CITY OF ALBUQUERQUE

April 26, 2012

Re: Folium Energy Solar Project, Annexation Portion Section 33
Grading and Drainage Plan
Engineer's Stamp Date 04-18-12 (M-21/D007E)

GRADING PLAN

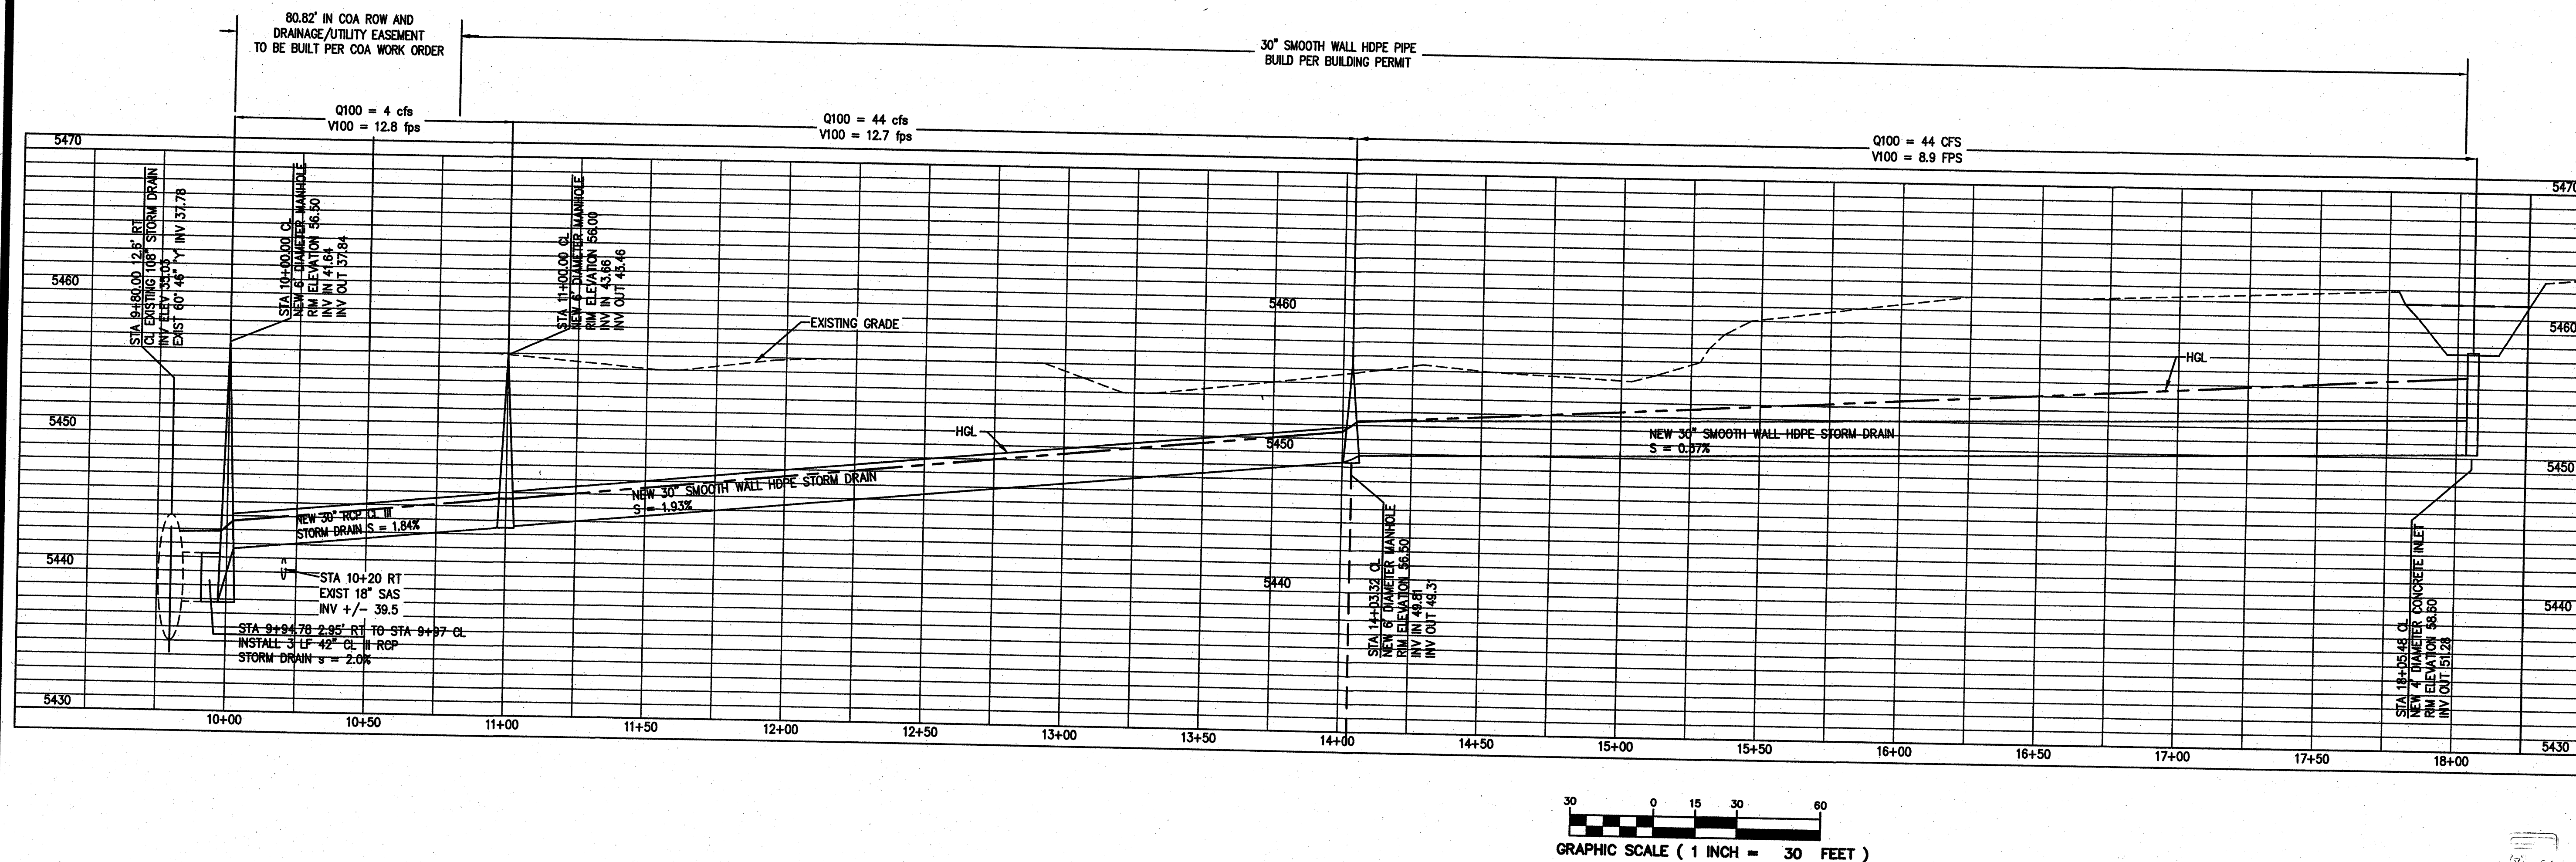
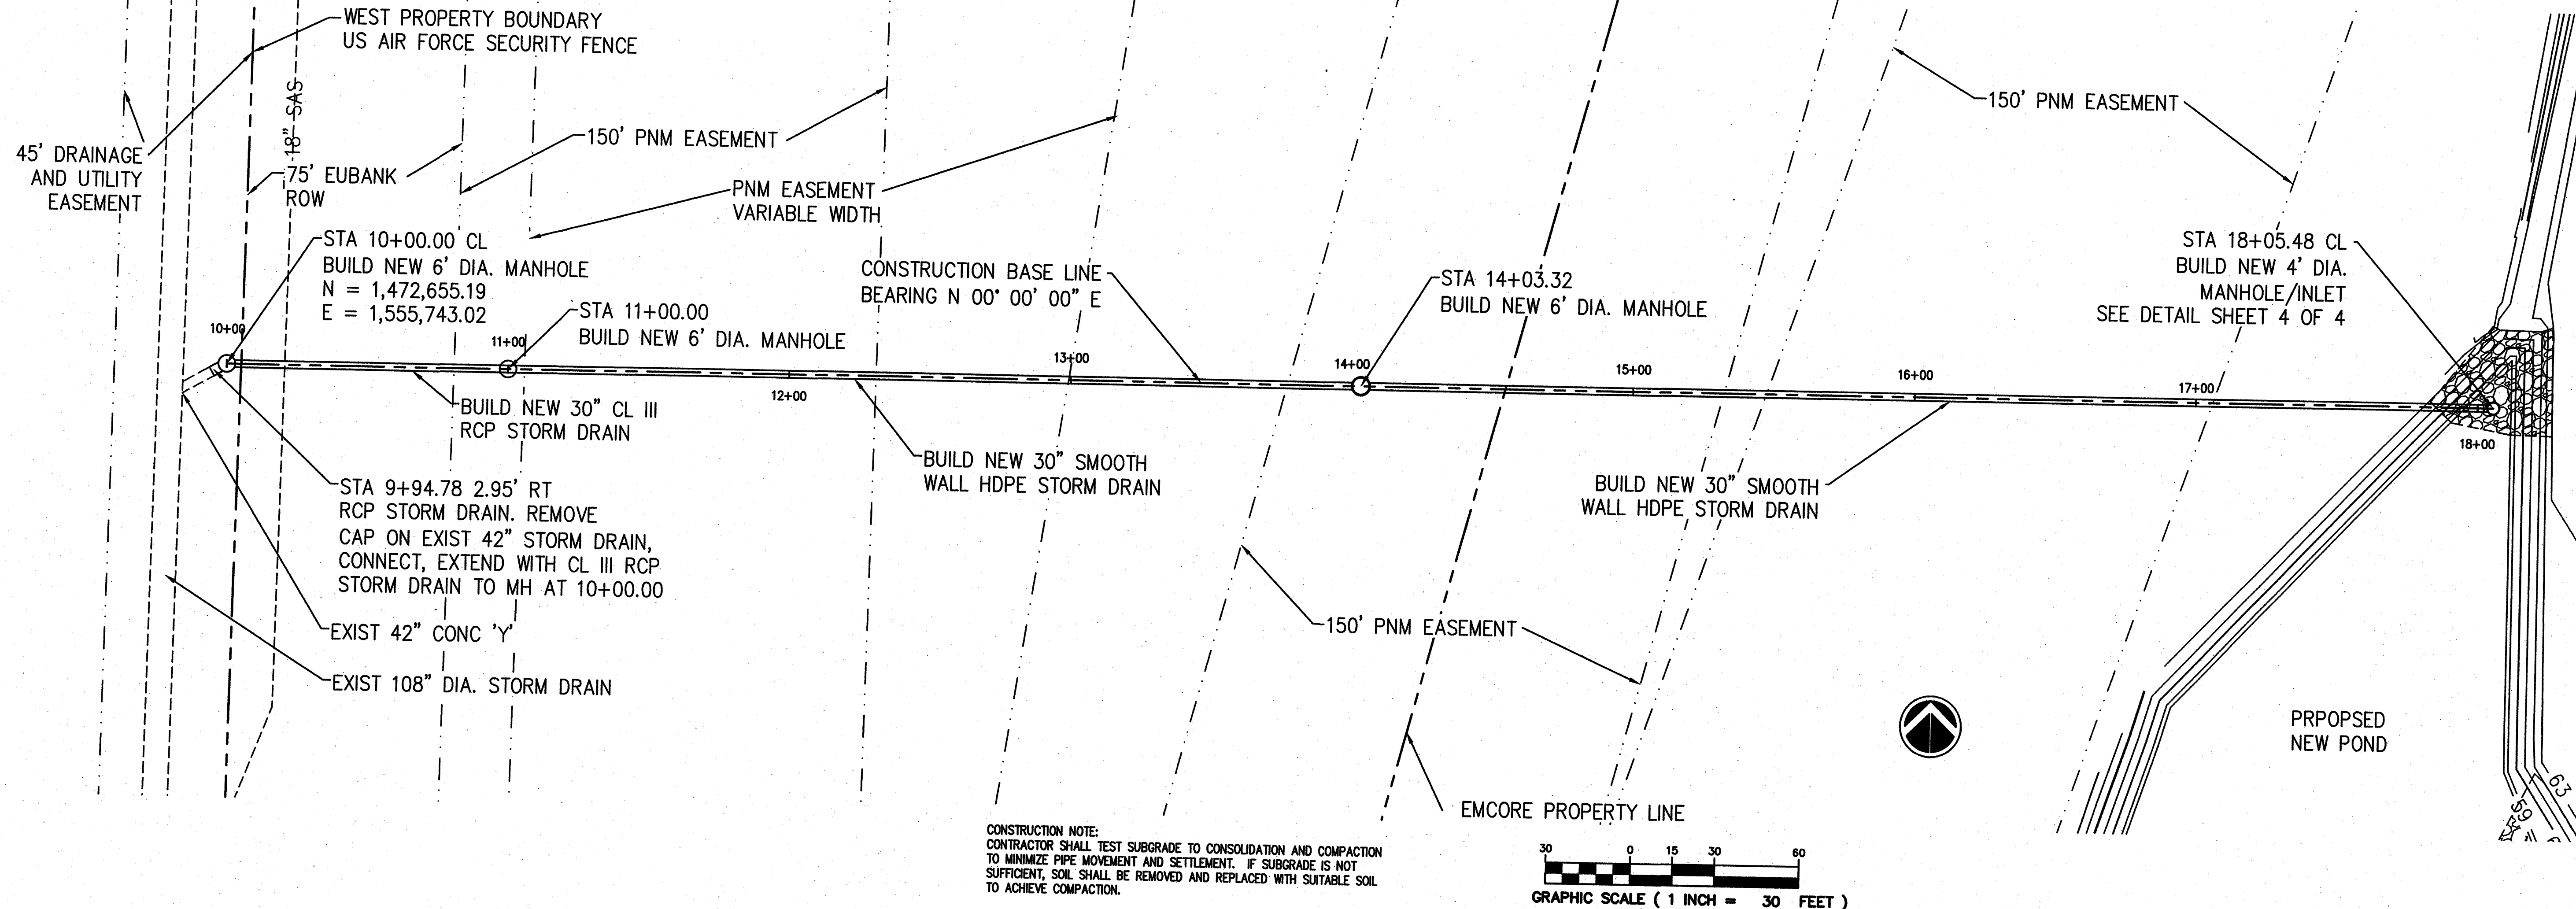
- The developed flows in Basin B should not consist of 100% Treatment B since this entire basin will be graded. The asphalt lined channels should be considered Treatment D with the other surface areas Treatment C.
- Off site flows appear to enter Basin B from the north/northeast boundary. Is there a berm located along the northern property line?
- The pond elevation and calculations will need to be updated due to the increased flows once the treatment types are corrected.
- Section "B-B" is listed on the grading plan but does not appear on Sheet 3.
- On Sheet 3 the Asphalt Channel Lining Section denotes a scarification and compaction of the sub-grade to a depth of "8 feet". Is this intended or should it read "8 inches"?
- Will the site contain an access road? If so this should be labeled on the grading plan.
- The North Arrow on the plan is incorrect.
